DRB Application No. 09DRB-70267 Project # 1004375
 Project Name: J&P
 Agent: Land Development Planning Phone No. _____

Re: San Antonio Self Storage
Project #1004375
Case # 08EPC 40108/Zone Map Amendment
40109 Site Development Plan for Subdivision
40124 Site Development/ Building Permit

FILE: **Project # 1004375**
08EPC 40108 Zone Map Amendment
08EPC 40109 Site Development Plan for Subdivision
08EPC-40124 Site Development - BUILDG PRMT

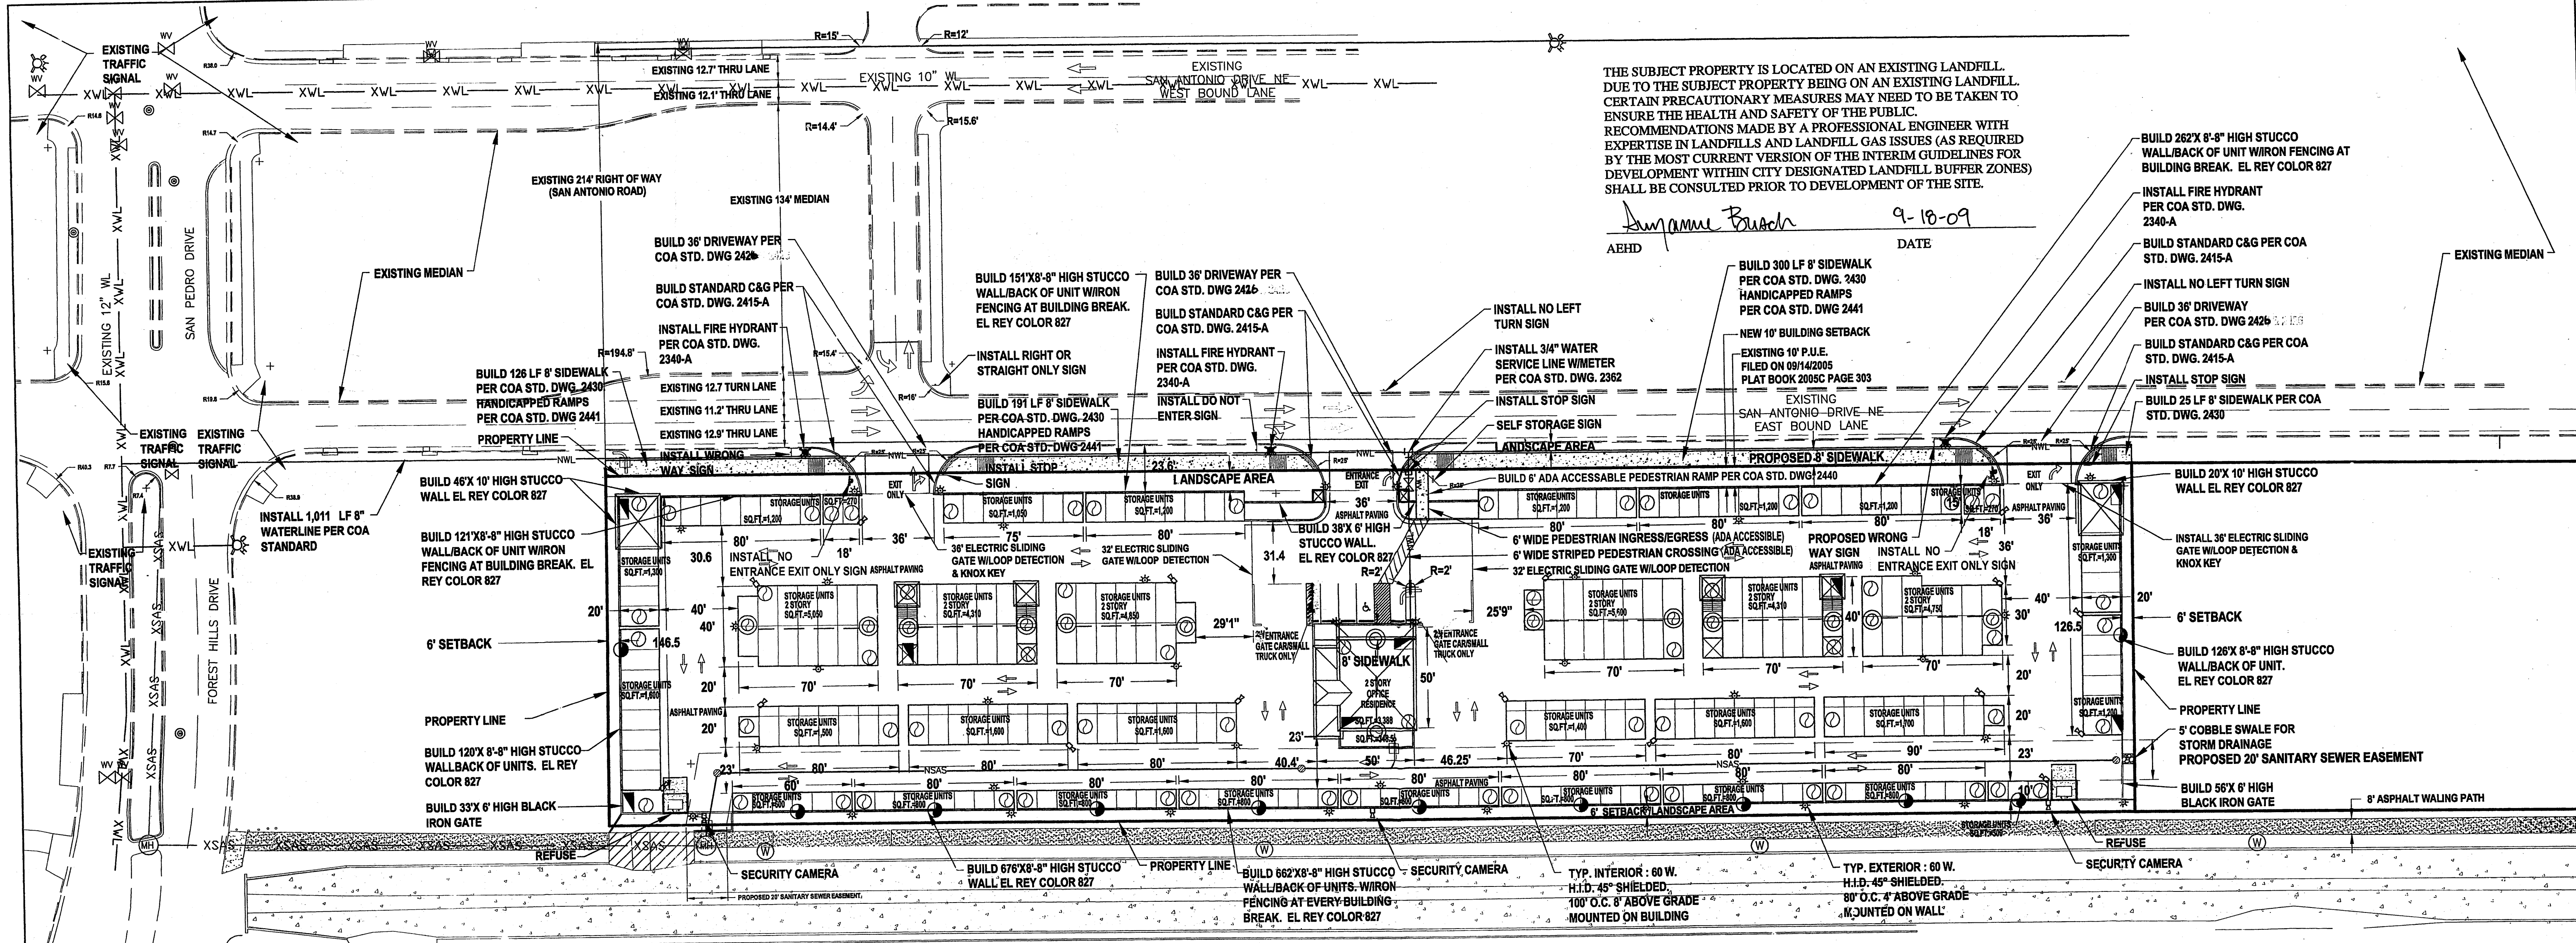
4. The 6' wide sidewalk along San Antonio Drive shall be 8' wide per Section 14-16-3-18(C)(1) of the Zoning Code.
5. RECOMMENDED CONDITIONS FROM CITY ENGINEER, MUNICIPAL DEVELOPMENT and NMDOT:

- Condition 3: Design standards on the site plan for subdivision and sign details have been modified to comply with City of Albuquerque standards.
- Condition 4: The sidewalk along San Antonio Drive has been modified to 8' (eight feet) wide per section 14-16-3-18 (c) (1) of the zoning code.

NORTH WALL ELEVATION SAN ANTONIO
SCALE: 1/4" = 1'-0"

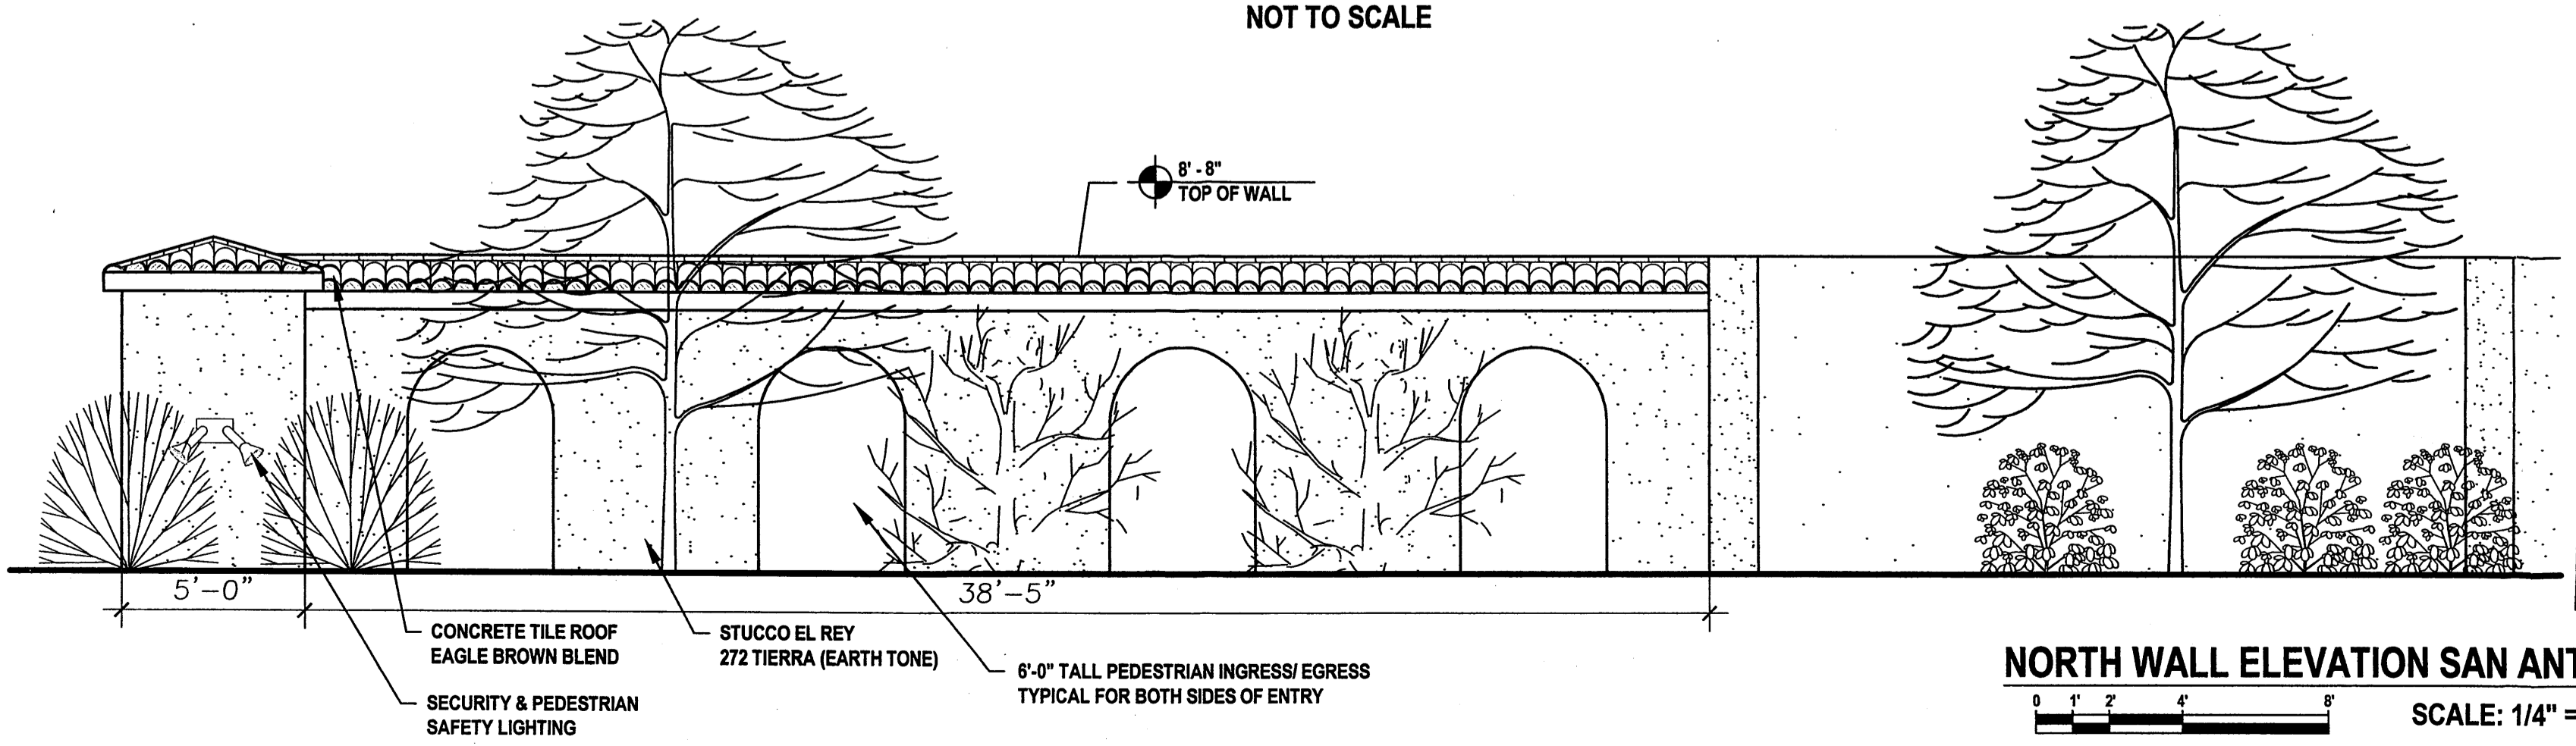
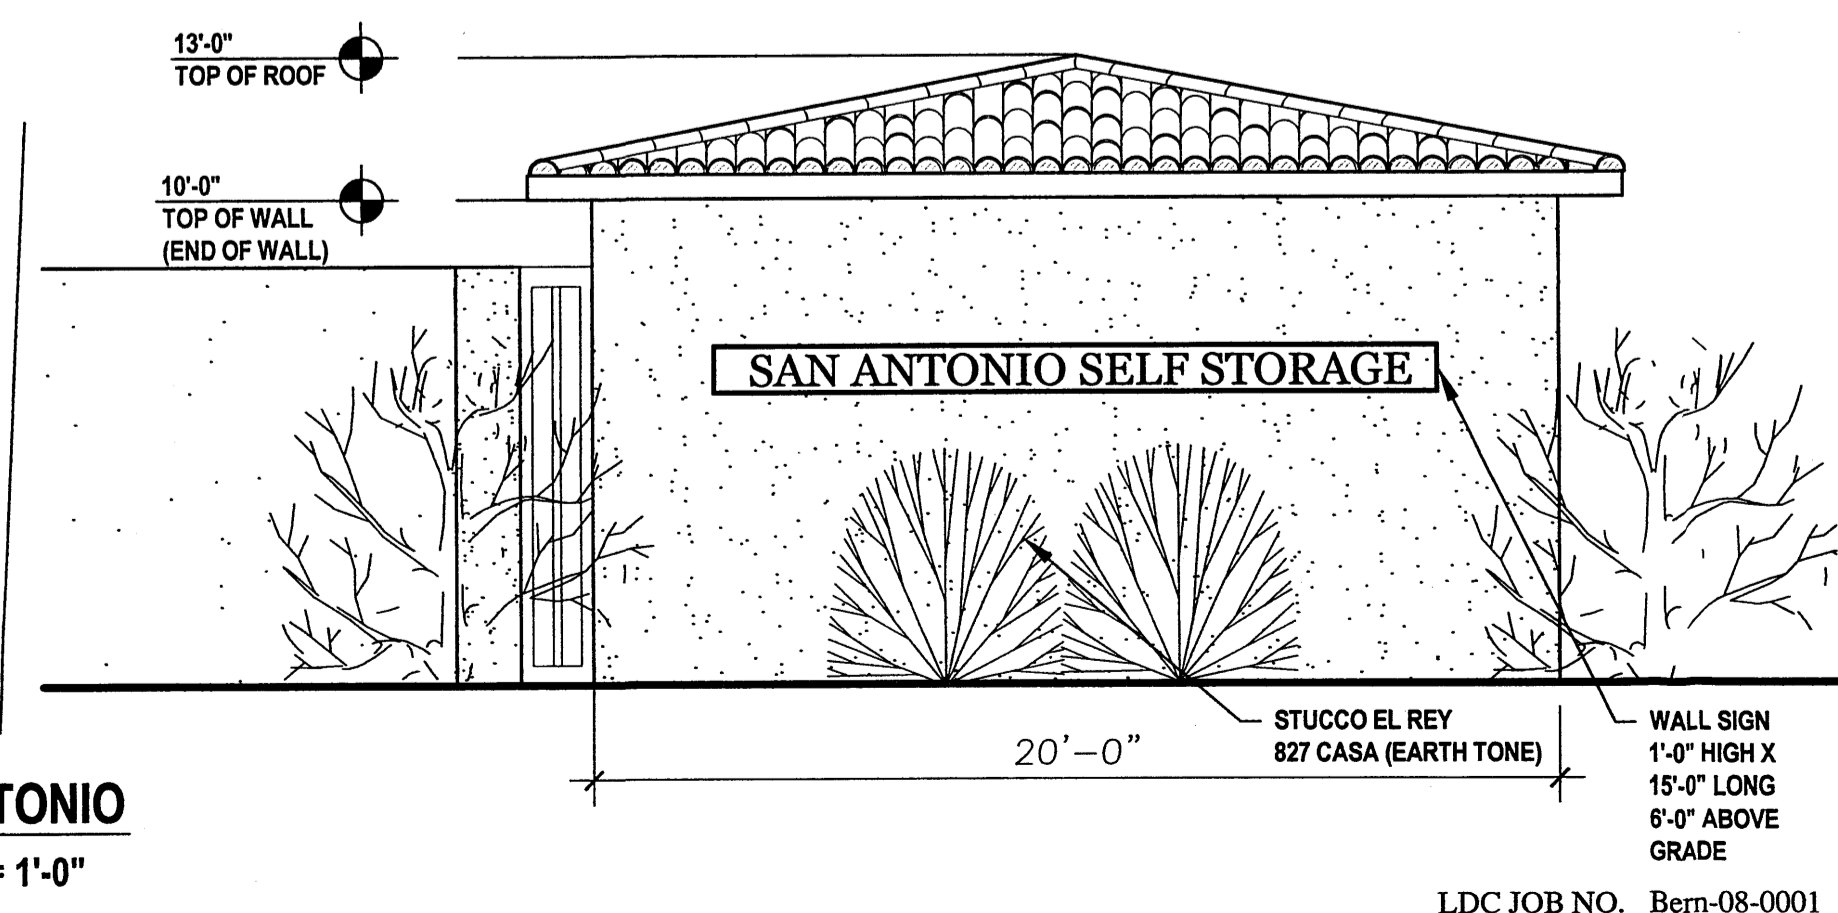
- c. Provide concurrence from Fire Department.
 - d. Site plan shall comply and be designed per DPM Standards
6. The height of the iron gate on the building elevations sheet (sheet 5-8) shall be 7 feet instead of 6 feet.

Condition 5: The height of the iron gate on the building elevations has been modified to 7 feet instead of 6 feet.
